M3 JUNCTION 9 IMPROVEMENT PROJECT

WRITTEN REPRESENTATION OF SOUTHERN WATER SERVICES LIMITED (URN 20036806)

15 June 2023

**PROJECT STAGE**  
 PCF STAGE 3

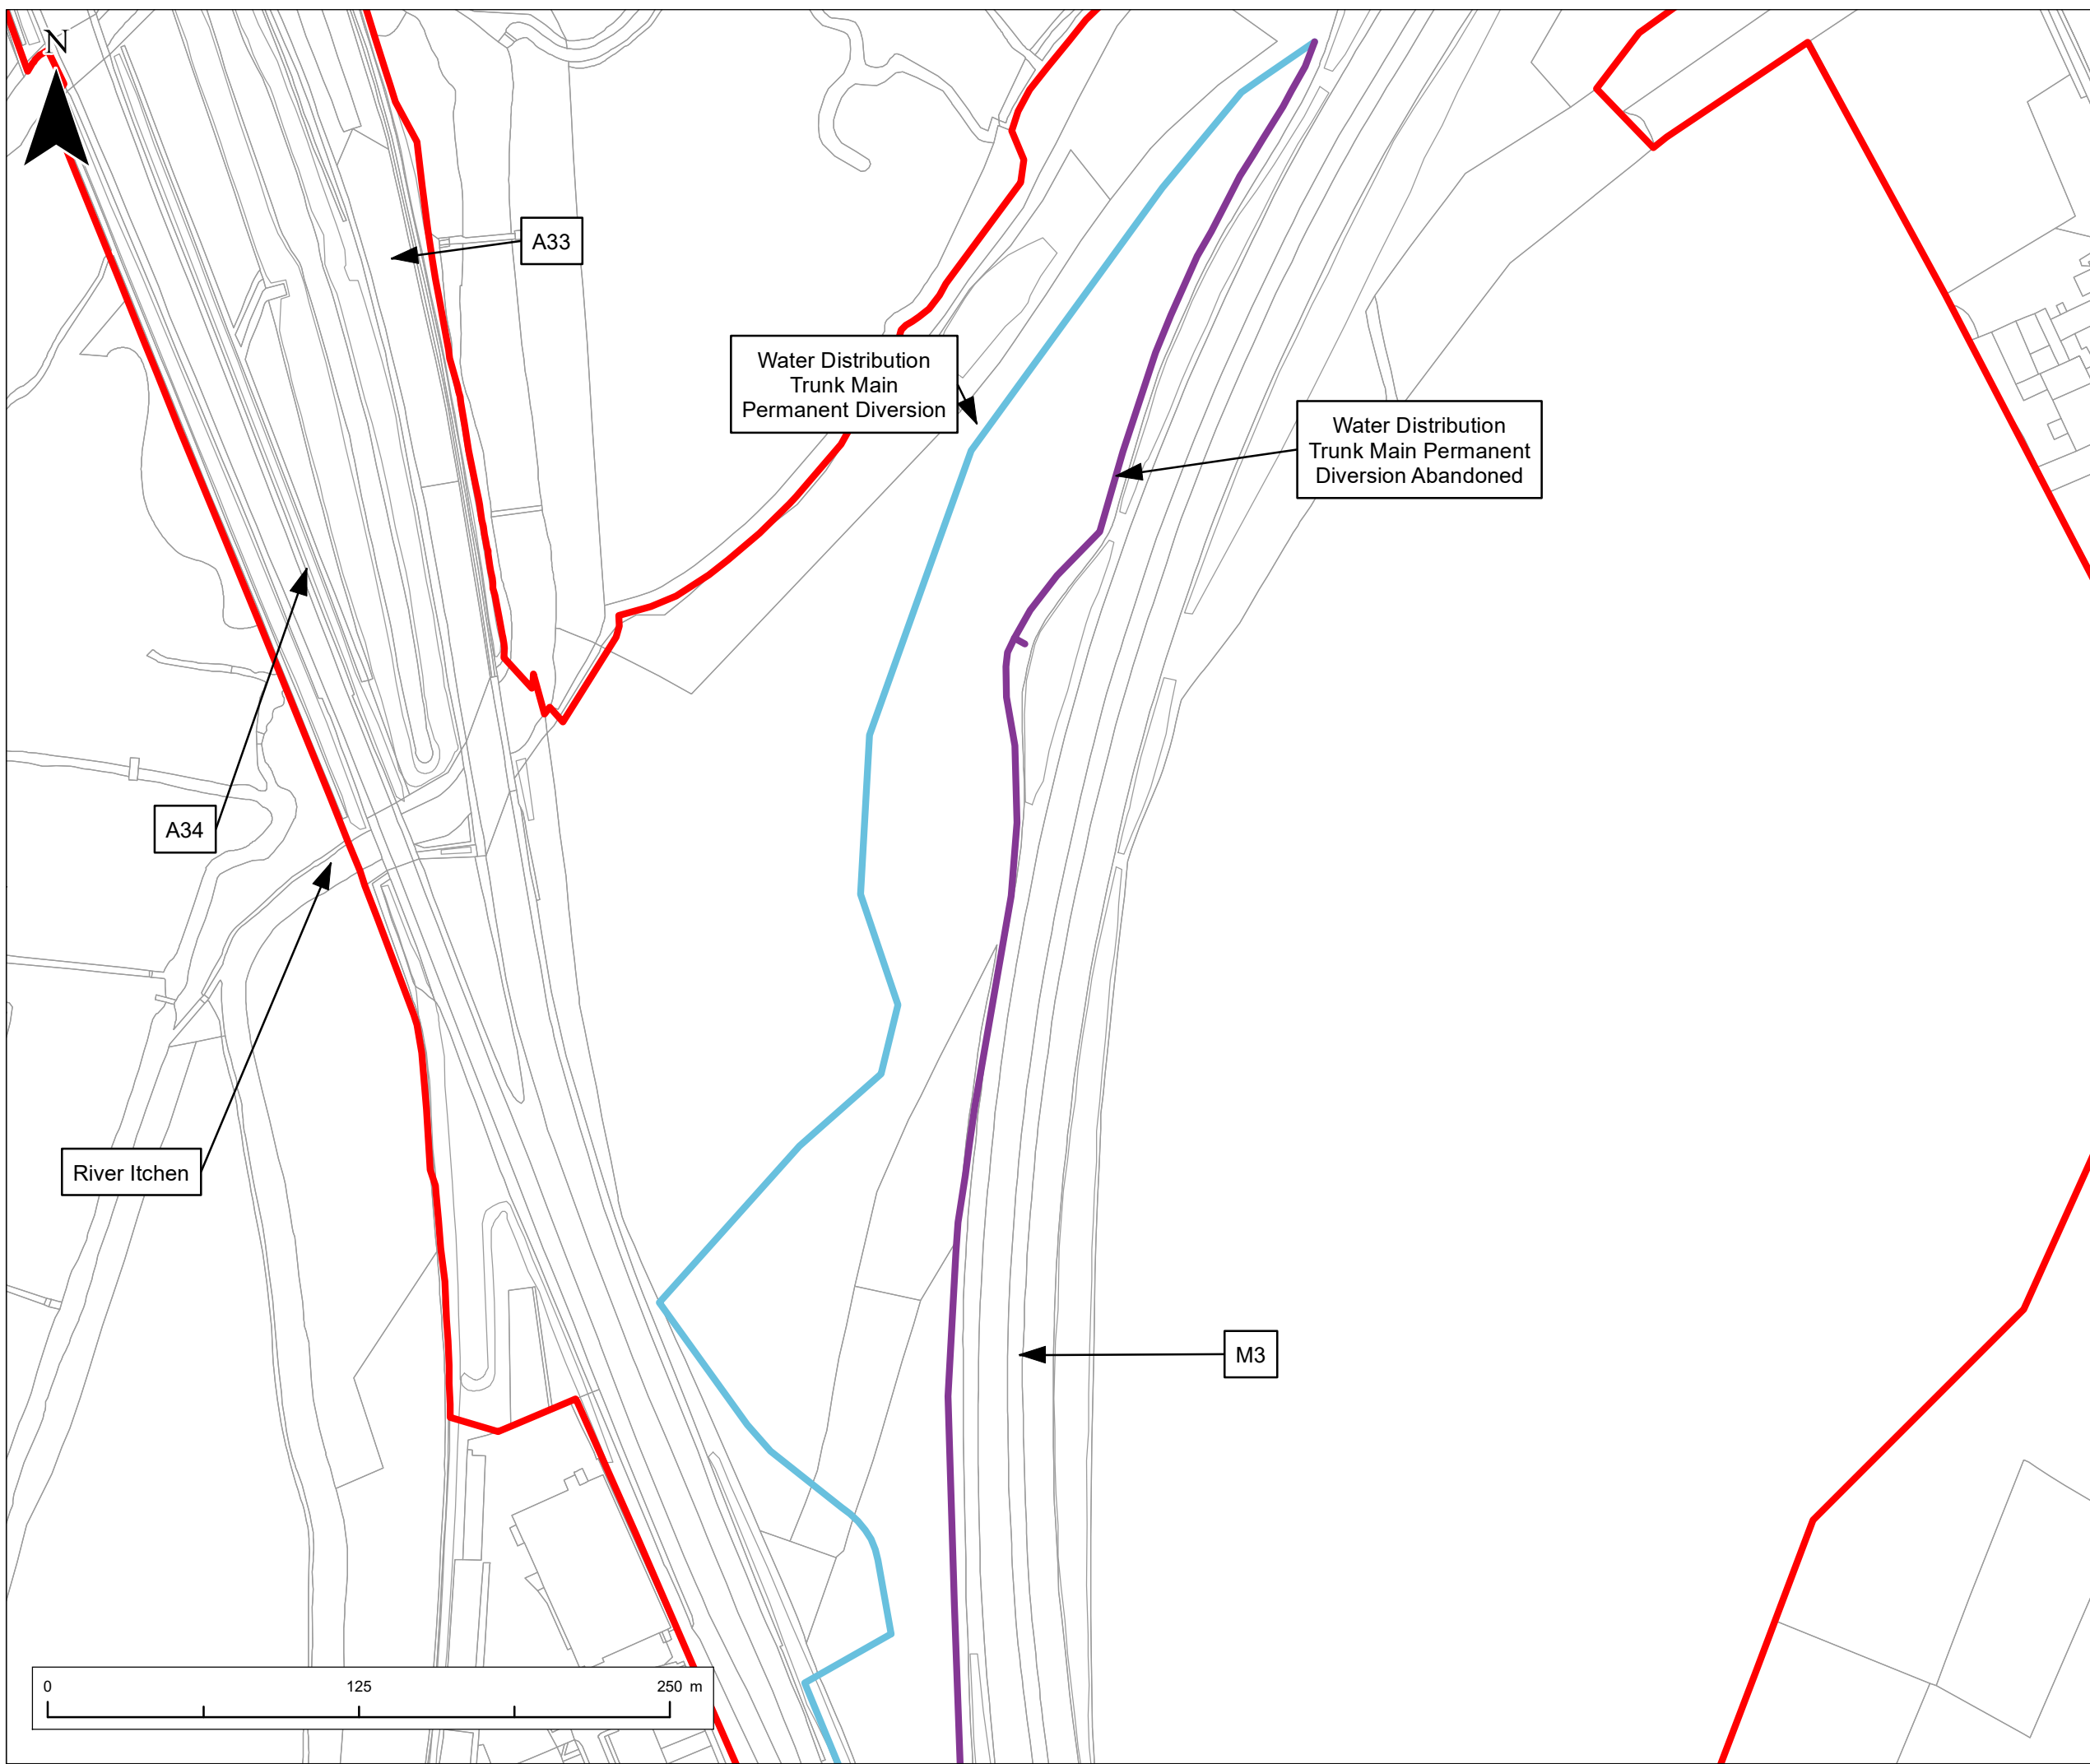
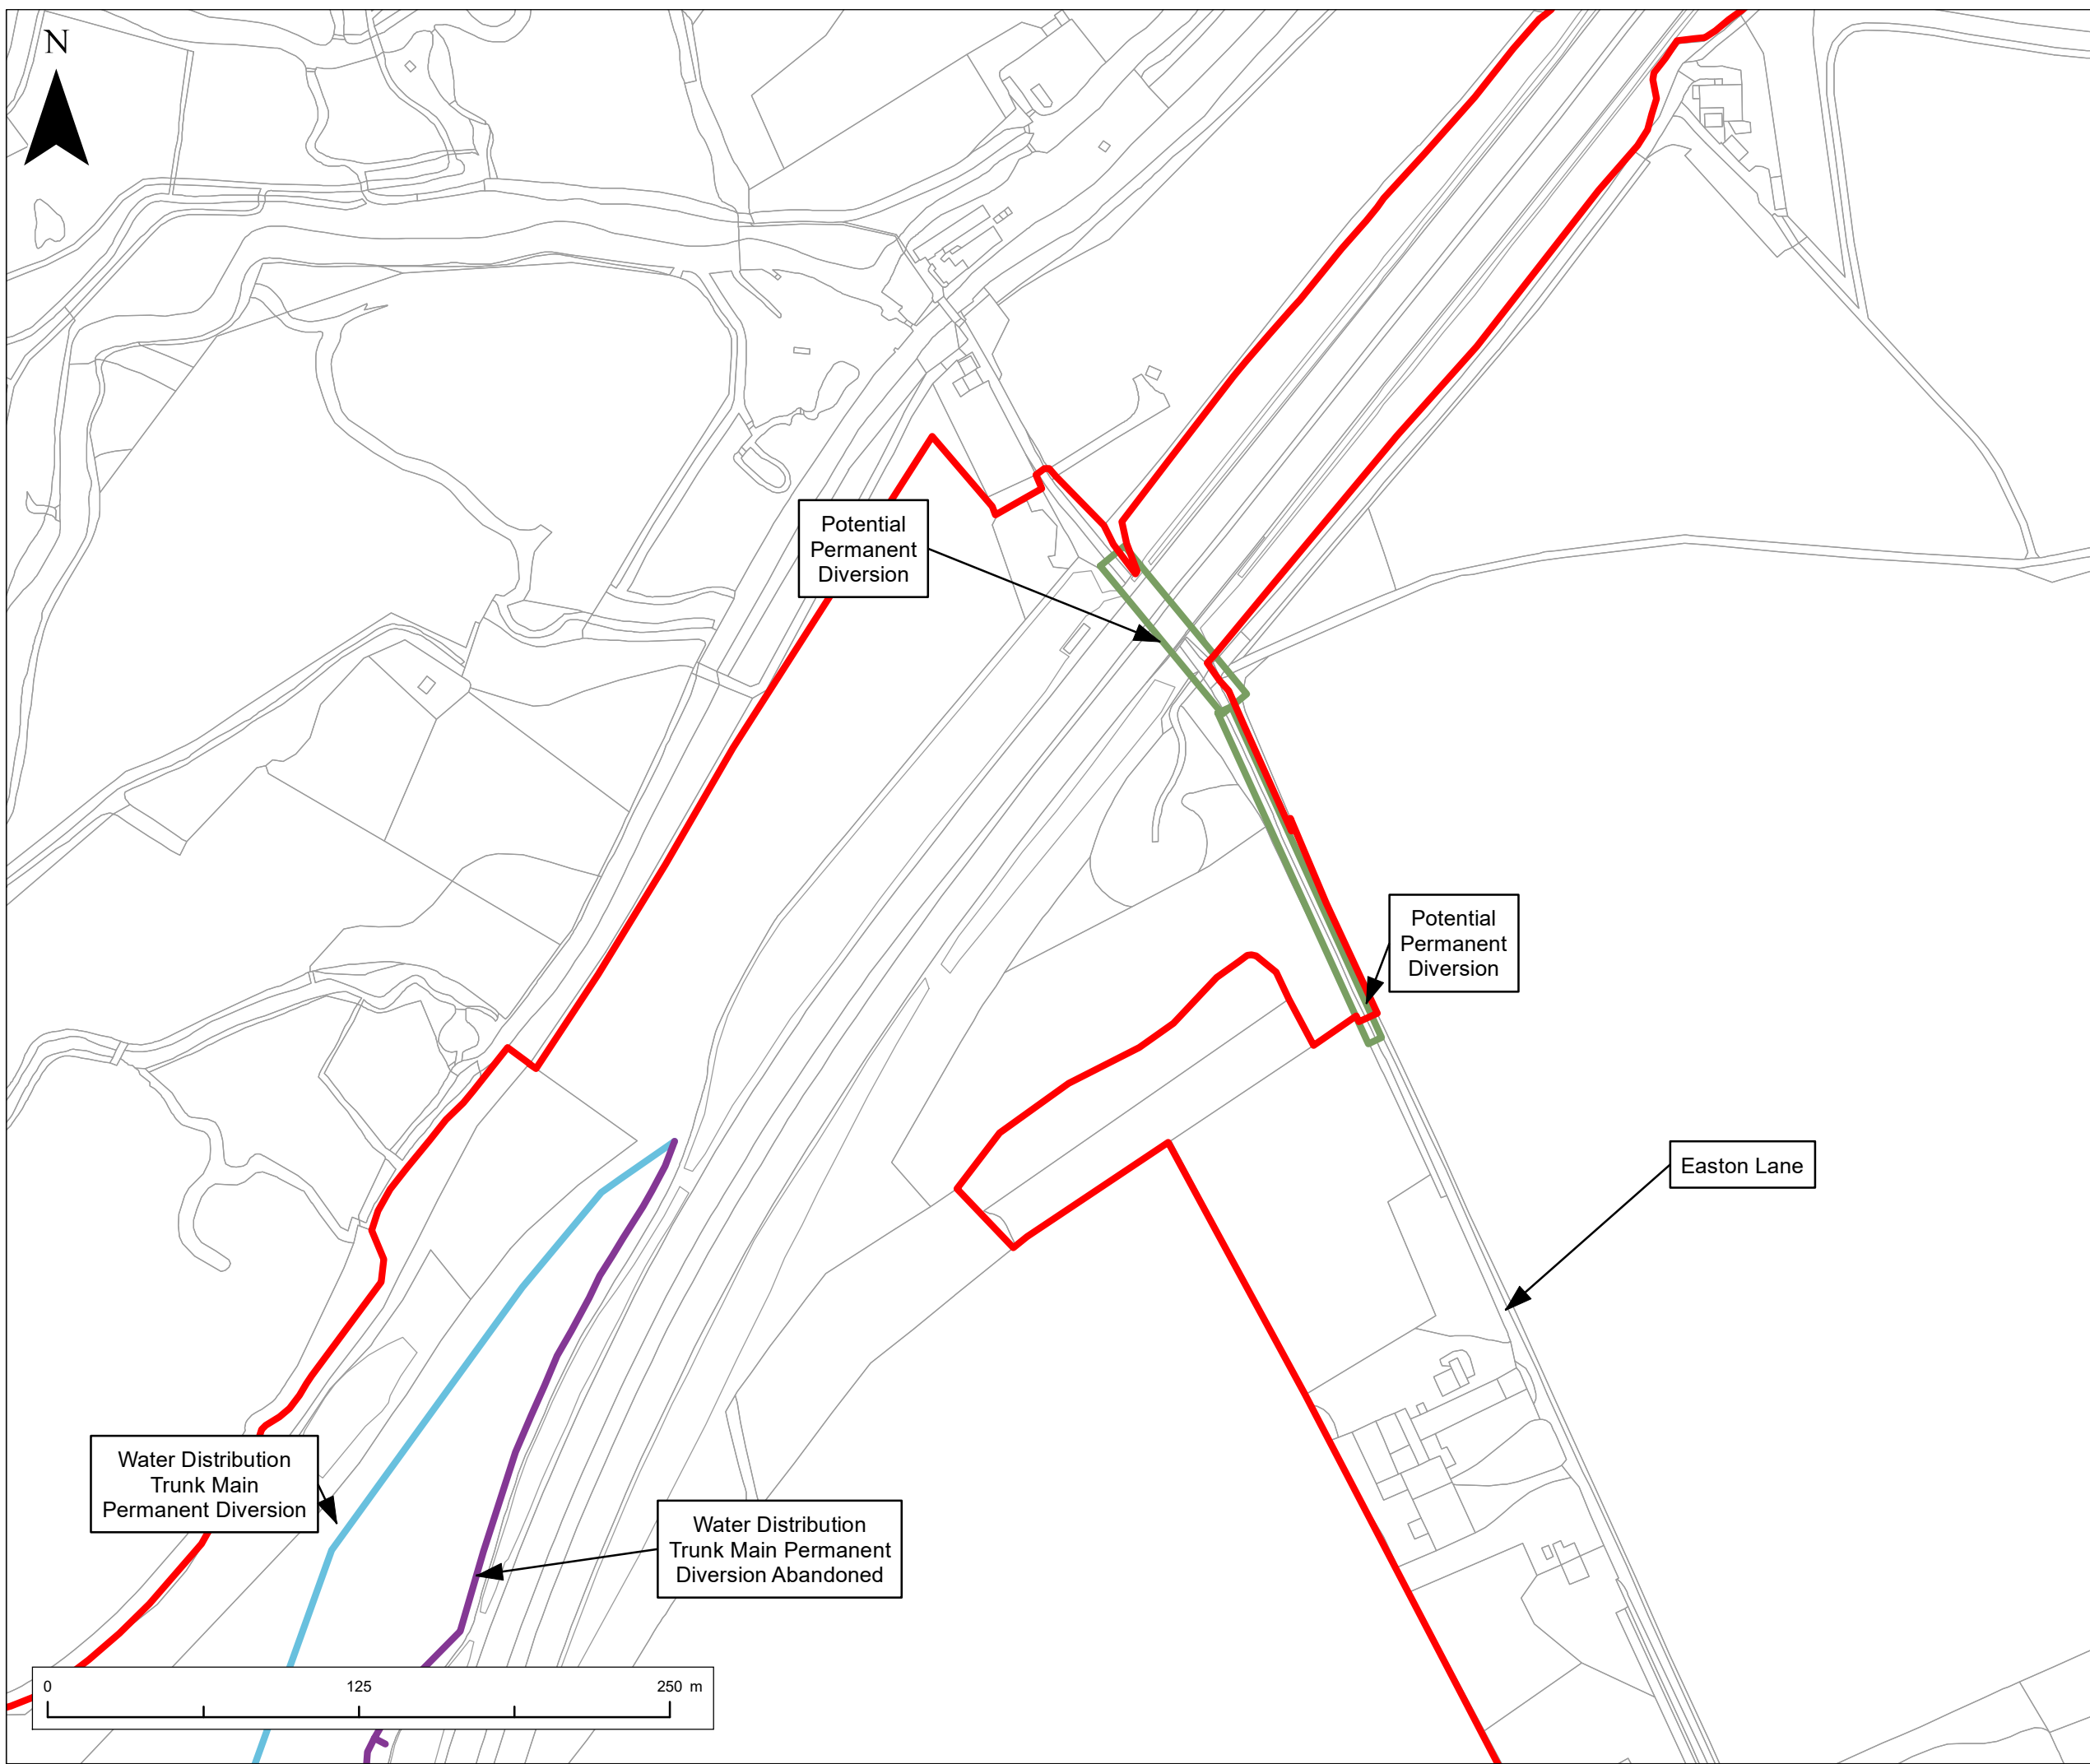
- 4.6. Southern Water notes the proposed diversion of the 300mm D.I (ductile iron) water main and understands that the work will be carried out in two stages, with a temporary main being installed in the first instance. The new main will be laid in 355mm HPPE (high performance polyethylene).

- 4.7. This is a strategic trunk main which serves a large number of properties in Winnall and surrounding areas. As such, it is vital that there is significant engagement with all parties involved with this diversion during the construction phase. In particular, there will need to be close management of the connections to the existing mains network to ensure that the impact to Southern Water's existing customers is mitigated as much as possible, to avoid unnecessary disruption.

- 4.8. The permanent diversion arguably places Southern Water in a worse position as regards future asset access and maintenance, by having two sections of ducted mains and the remainder in highway embankments behind industrial units on Moorside Road, where currently all pipe is in the relatively more favourable setting of agricultural land. Southern Water wishes to discuss this further with the Applicant.
